Date 2/11/2018
To Steve Ryan (Tactical Group)
From Westley Owers (Arcadis)/ Richard Johnson (Aspect)
Copy to Nathan Cairney (Tactical Group)
Subject MPW Stage 2 – DP&E assessment matrix – SIMTA summary response

Table 1 Summary of DP&E comments

Drawing No.	Project No.	Issue
C-MIC2-SSD-116-AA003760		04

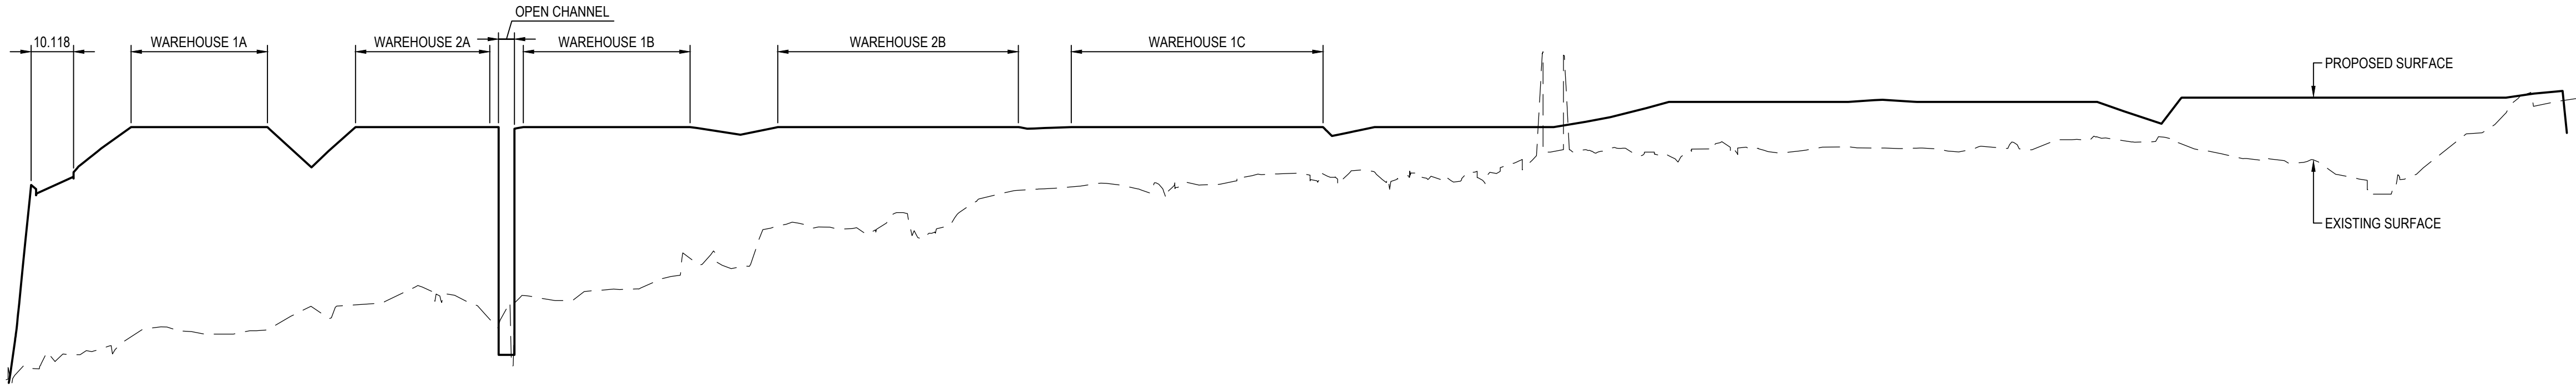
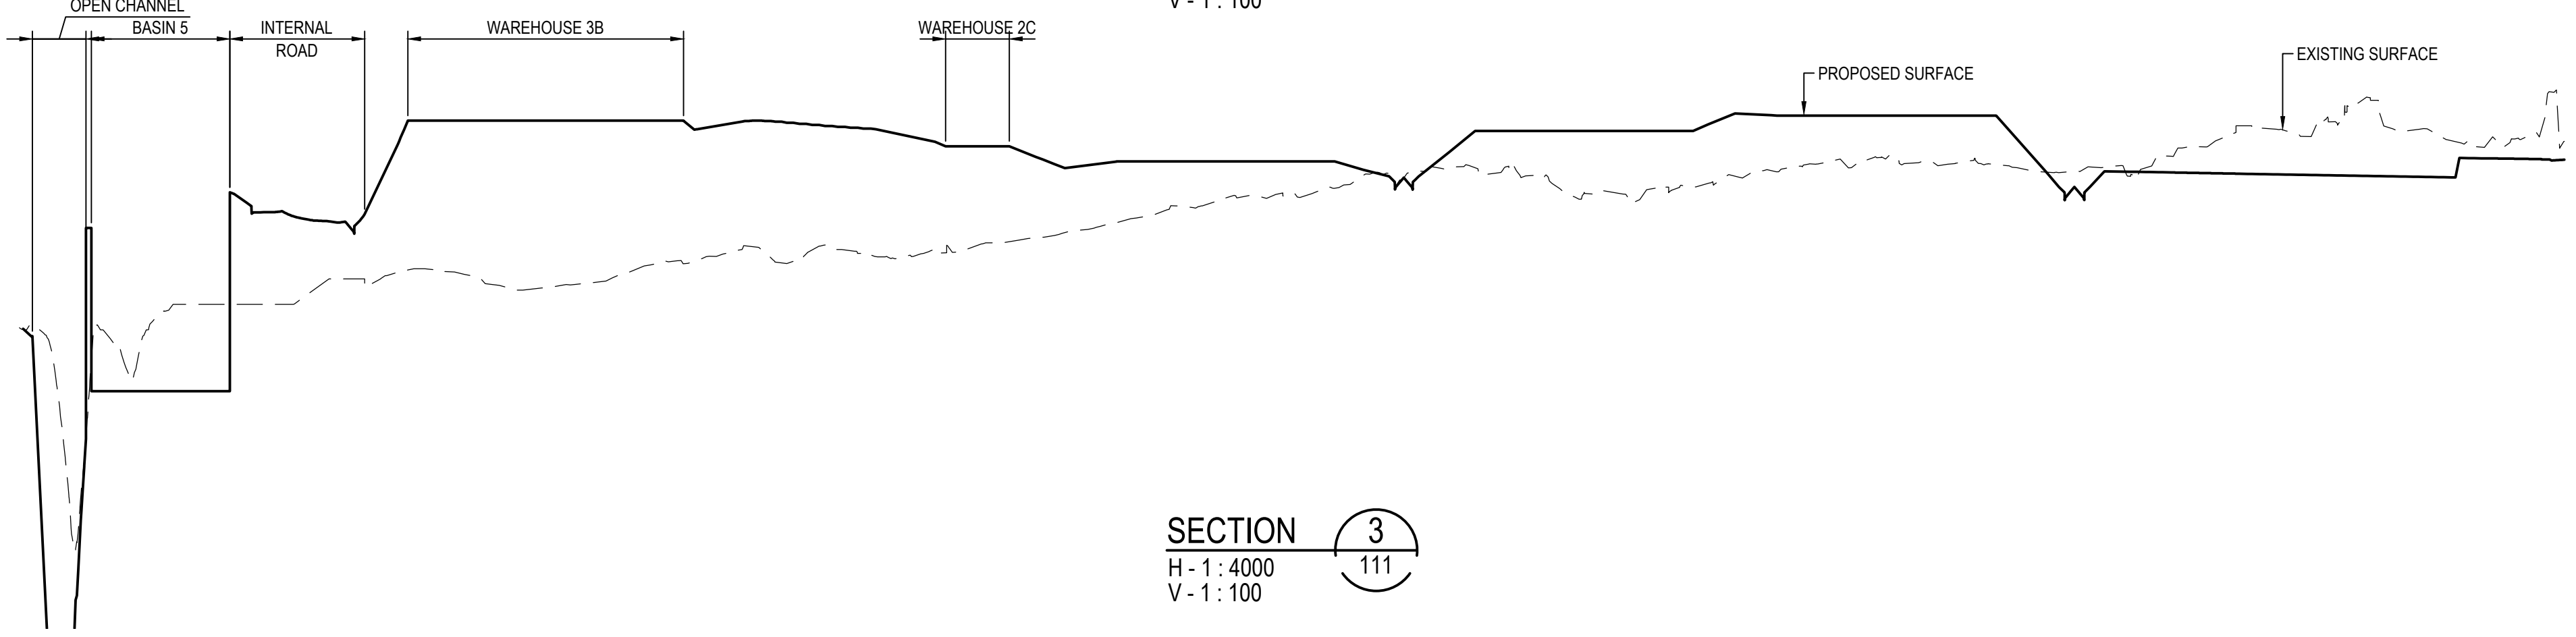
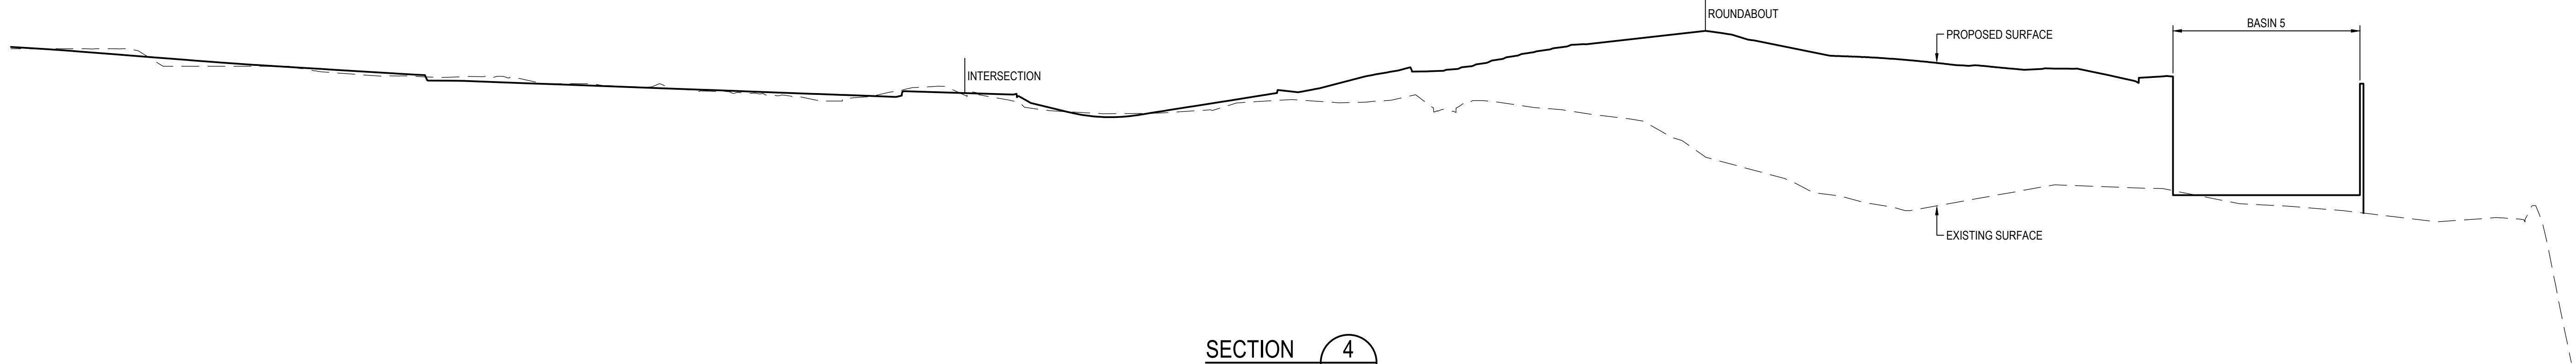
Issues for Assessment – Assessment Report unable to be Finalised	DP&E previous Classification	Initial response	Discussion notes
3. Revised C-MIC2-SSD-116/117 (Earthworks Sections Sheet 1 and 2) Cross-Sections including noise wall showing tie in to existing adjacent surface levels, location of top of bank to the Georges River and extension of cross-sections/ additional cross-section as follows:

3.1 extension of Section 2 to the north to show tie in with existing levels (also to show location of boundary between Lot 1 DP 1197707 and Lot 3 DP 32998 (ABB site))	Outstanding item	<ul style="list-style-type: none"> Civil Design Drawings (MPW2-ARC-CV-DWG- 0121) – Refer to Appendix B. 	Considered addressed.

3.3 extension of Section 3 to the south to show tie in with the railway embankment	Outstanding item	<ul style="list-style-type: none"> Civil Design Drawings (MPW2-ARC-CV-DWG- 0121) – Refer to Appendix B. 	Considered addressed.

3.4 additional Section through basin 8 and end of basin 10 extending east to Moorebank Avenue and west to the top of the Georges River bank.	Outstanding item	<ul style="list-style-type: none"> Based on the location of Basin 8 and Basin 10 this cannot be achieved. 	For discussion with DP&E.

Title
CIVIL WORKS PLAN SHEET 1

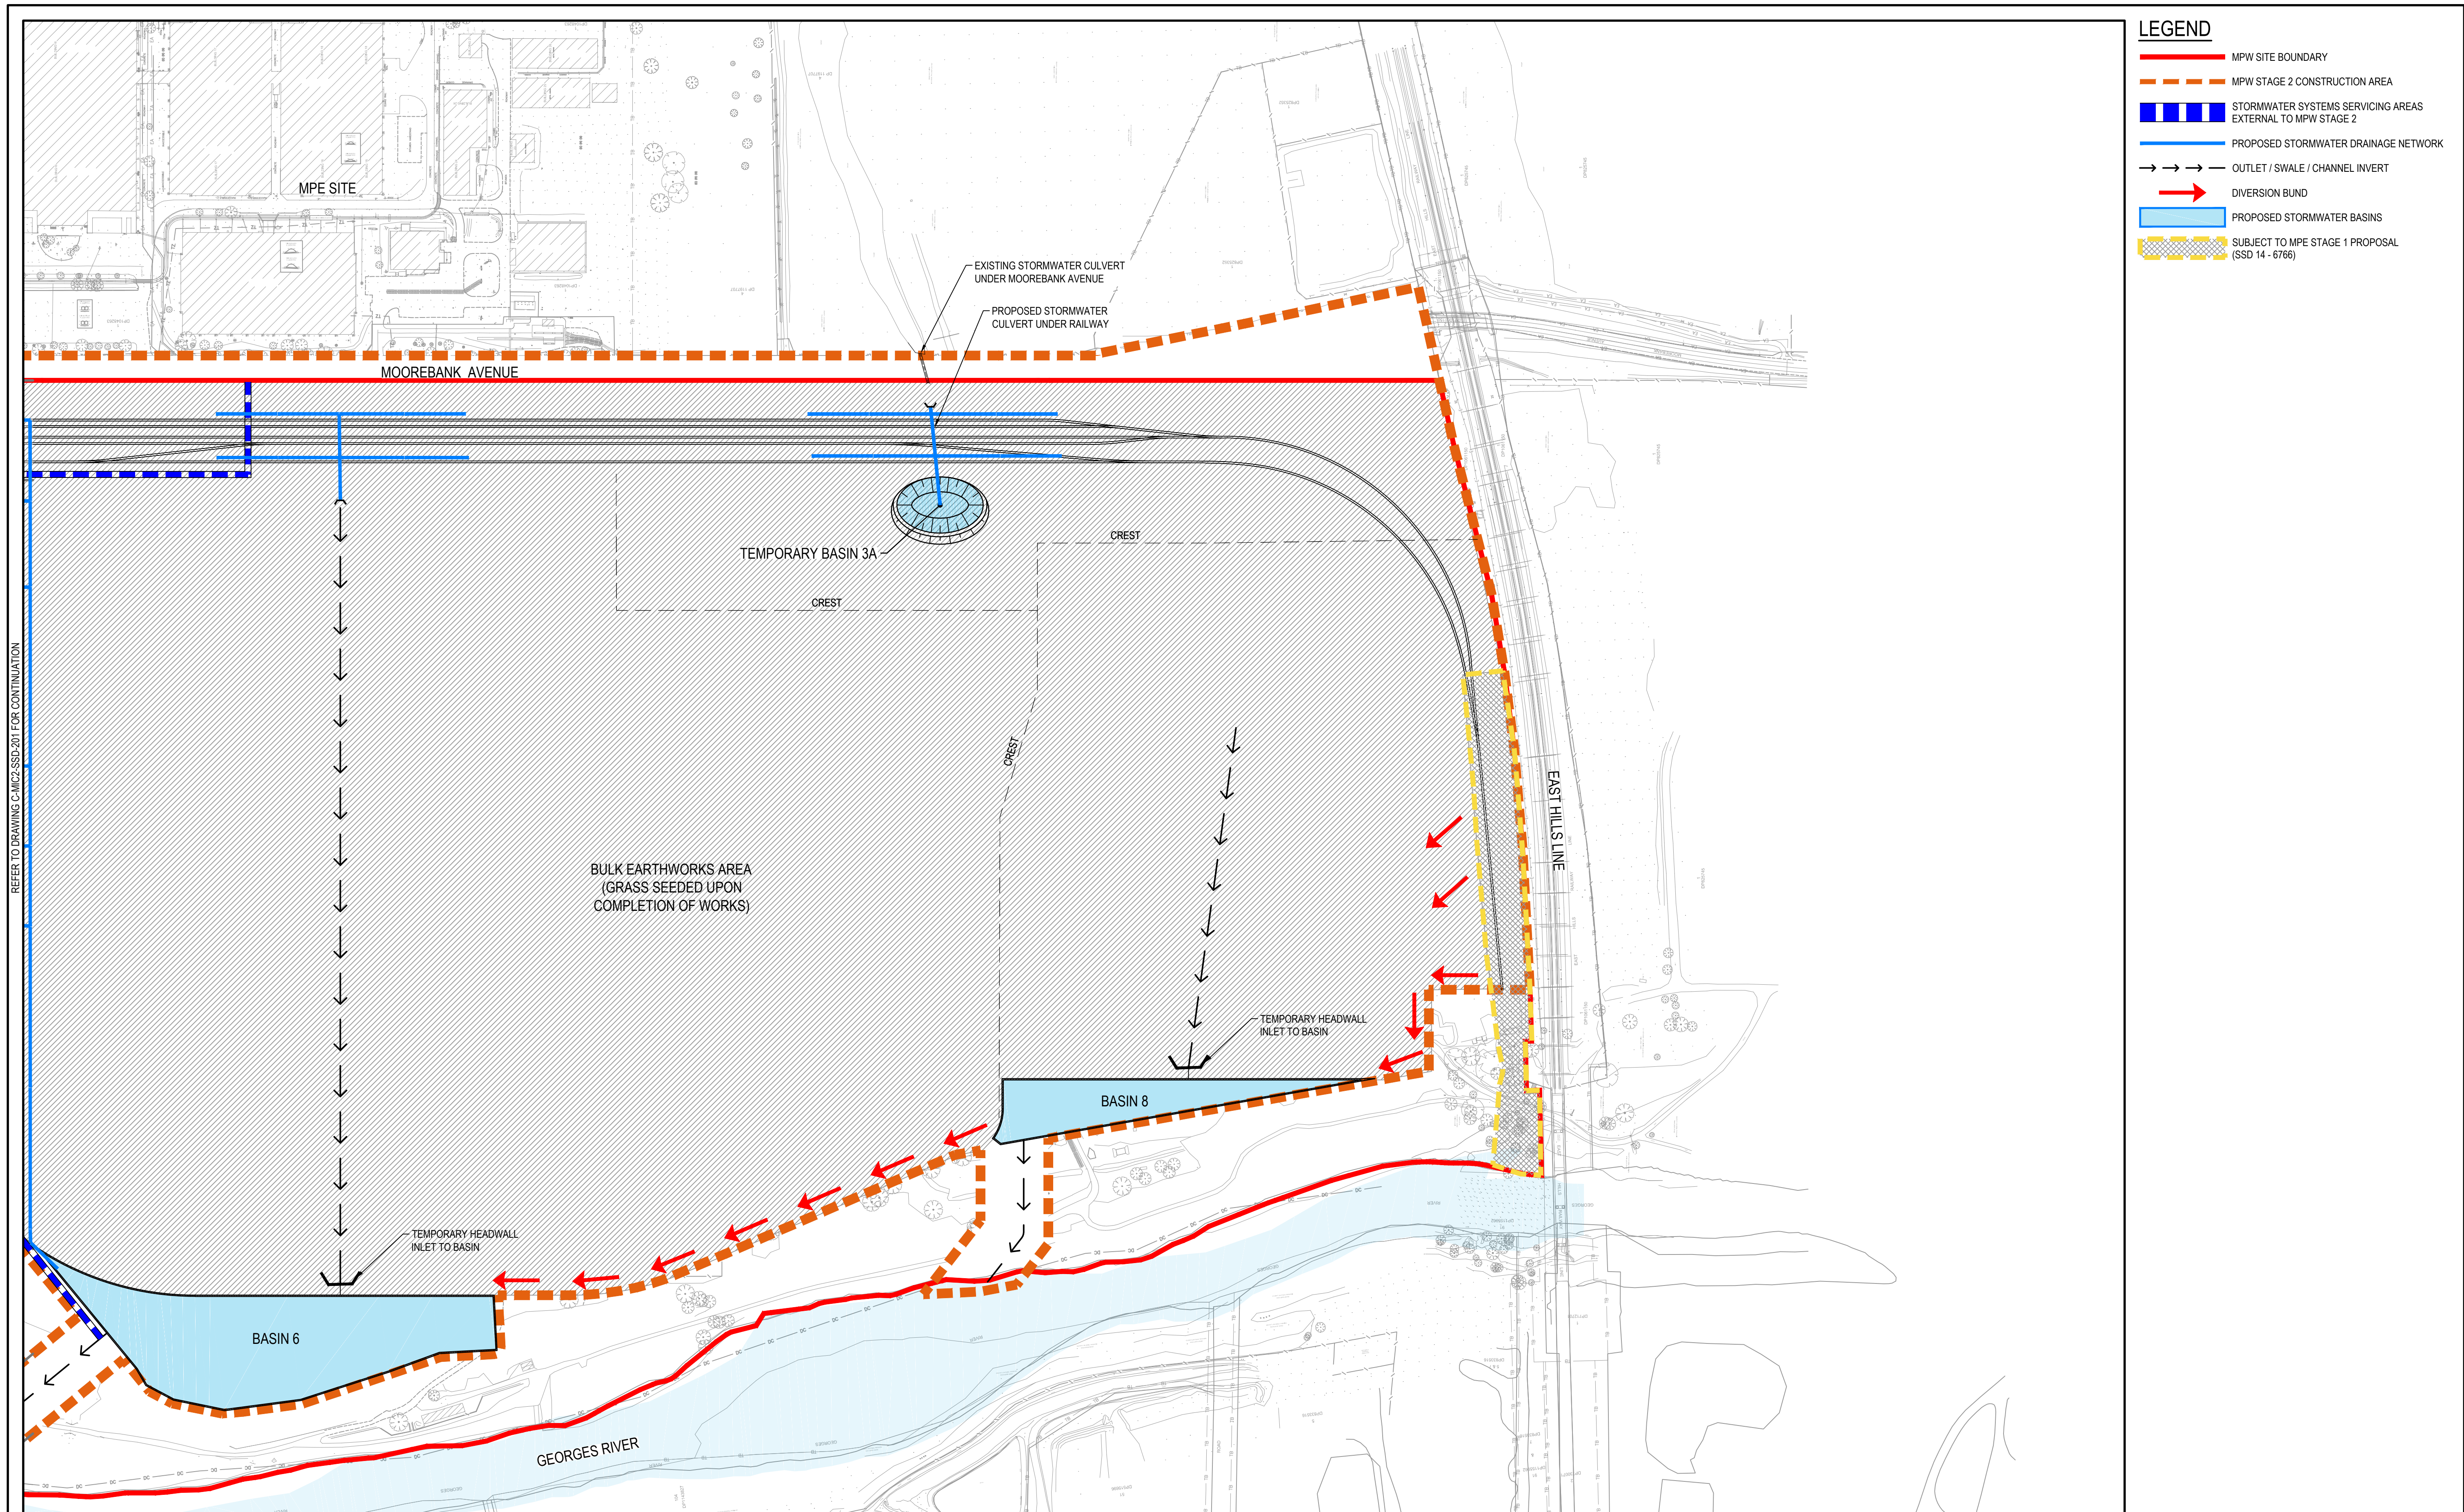
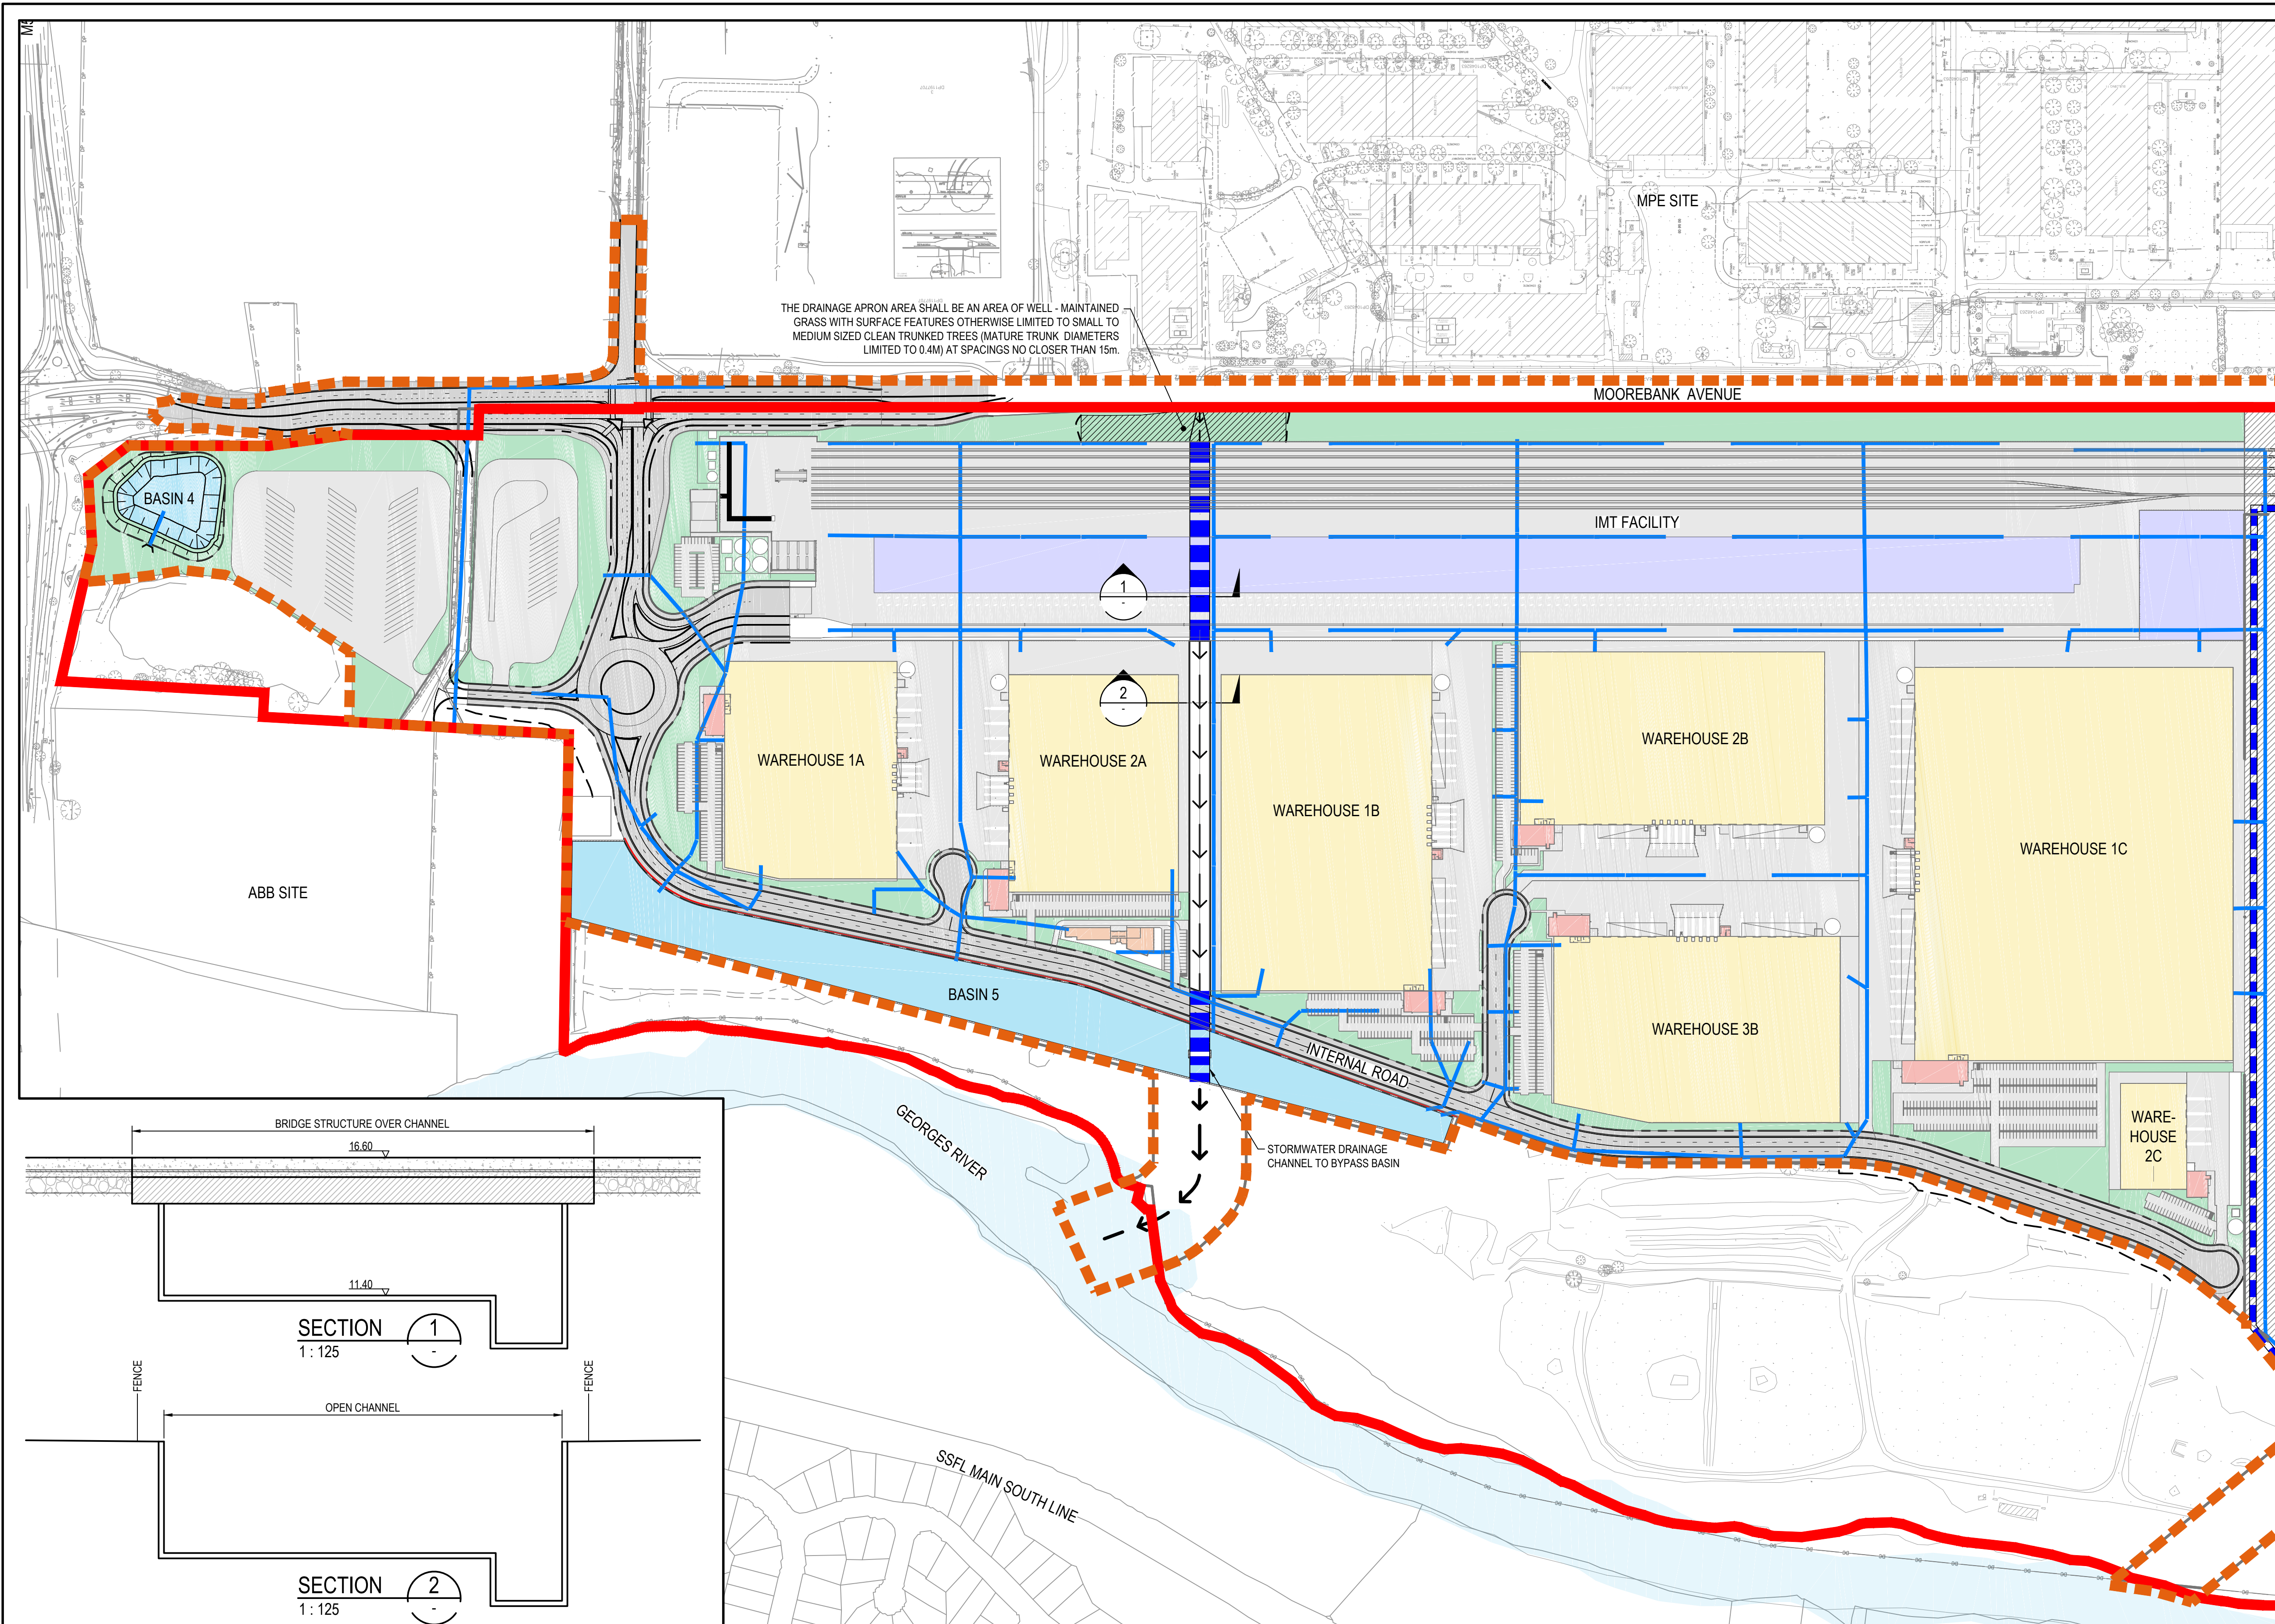
2.14(iii) fill batters removed from plan, no information provided	Item not considered adequate	<ul style="list-style-type: none"> Fill batters have been provided on plans, as identified in the Civil Design Drawings (MPW2-ARC-CV-DWG- 0002) – Refer to Appendix B. 	For discussion with DP&E.
